ENG-CDR23021-R2-FDR-S2.pdf Markup Summary

Include reference material (see items mentioned throughout the report to include)

SHEET DRN 1  
 PROPOSED CONDITIONS - DRAINAGE MAP

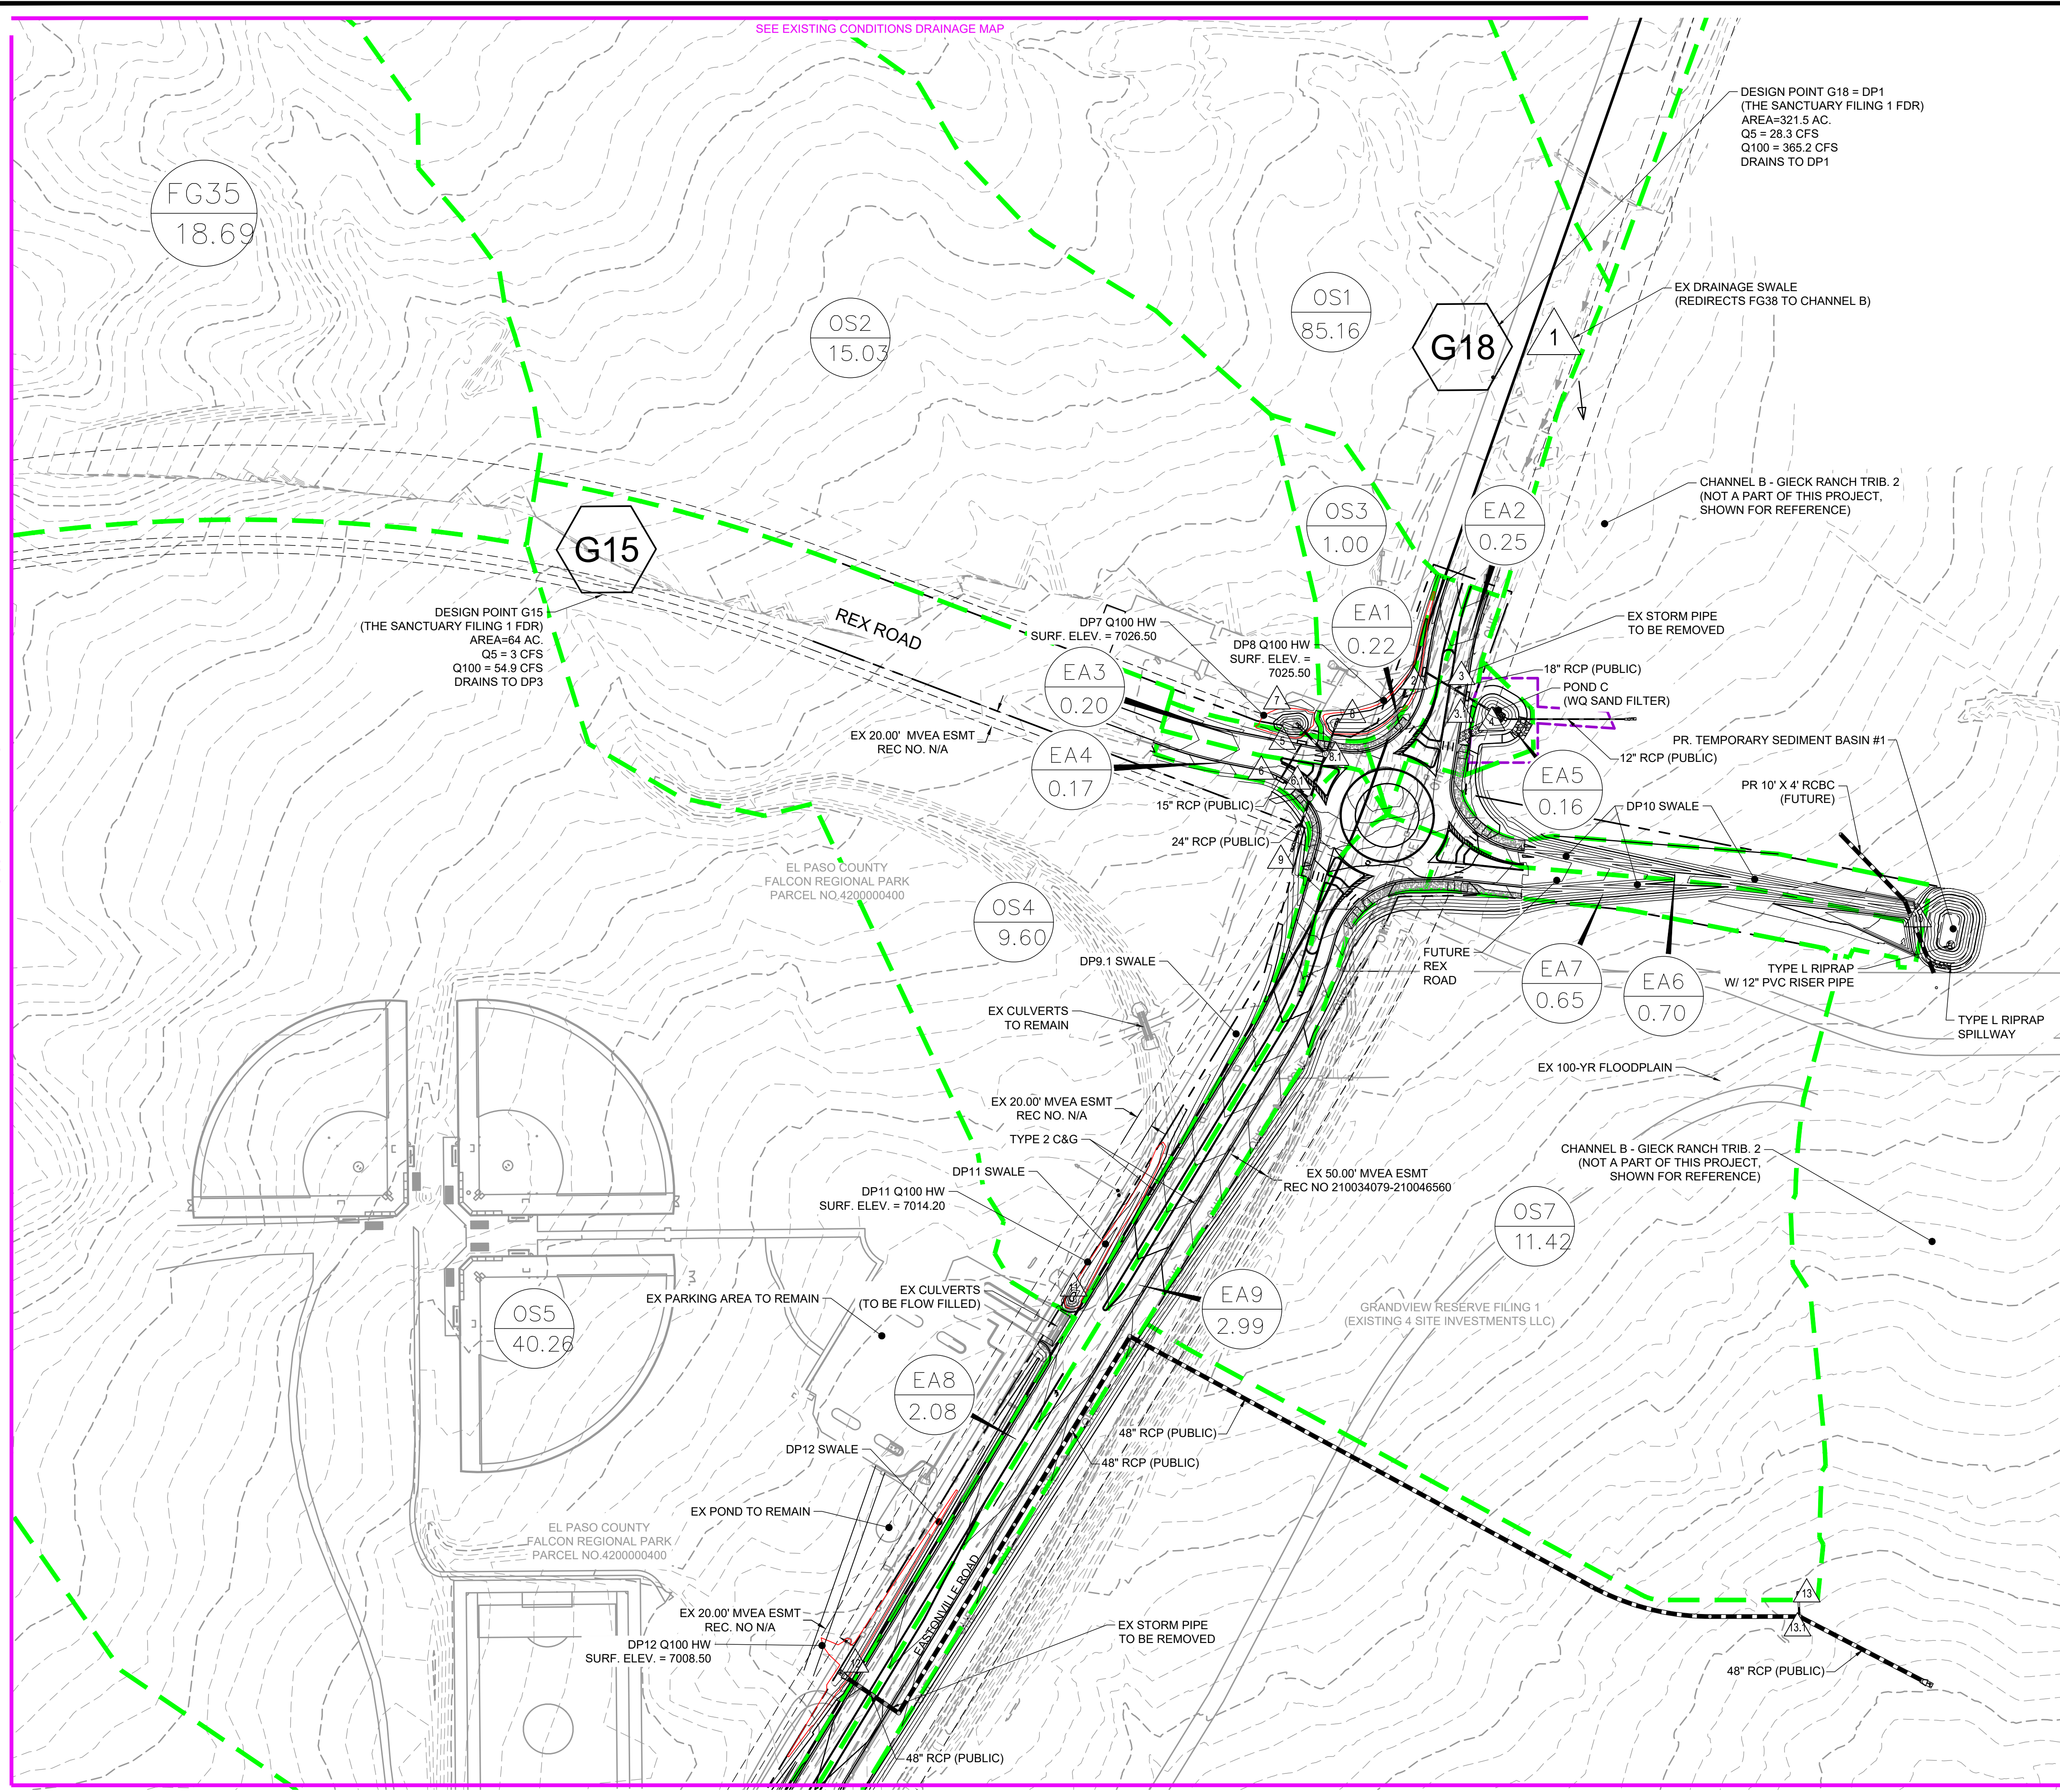
Unresolved:
Is there a wall along here? If so, please label

Unresolved:
Add additional contour labels

Provide MH size

Can't read label

Unresolved:
Label road and include ROW width and classification

Unresolved:
 Ensure all existing and proposed easements are labeled

Missing Basins OS1, OS2, OS6 & FG35 in summary table.

These are design point labels. Please move to design point table and list corresponding basins in this table.

Label all storm infrastructure, include if public/private and existing/proposed/future.

Label inlets and include if sump/at-grade and size

Label drainage easement. Easement needs to include all of riprap.
